The CTMP must be appropriately titled, include the site and planning permission number.

Site Plan

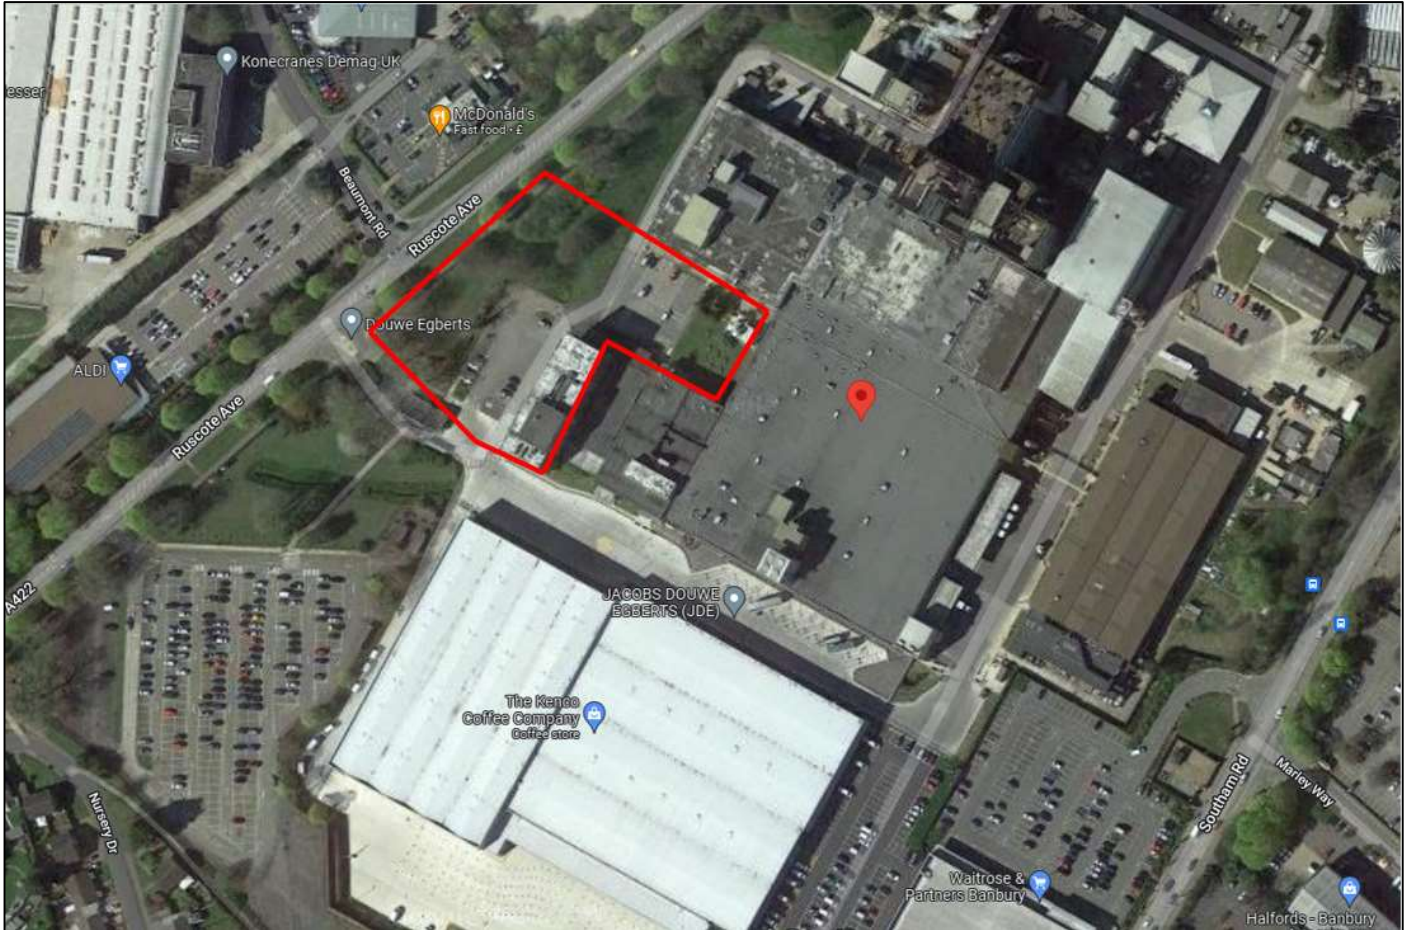
- Parking will be available onsite for workers and visitors, visitors will be made aware of this upon arrival.
- Map or diagram required detailing the location of these spaces in relation to the site

- Layout plan of site to be added and submitted within CTMP
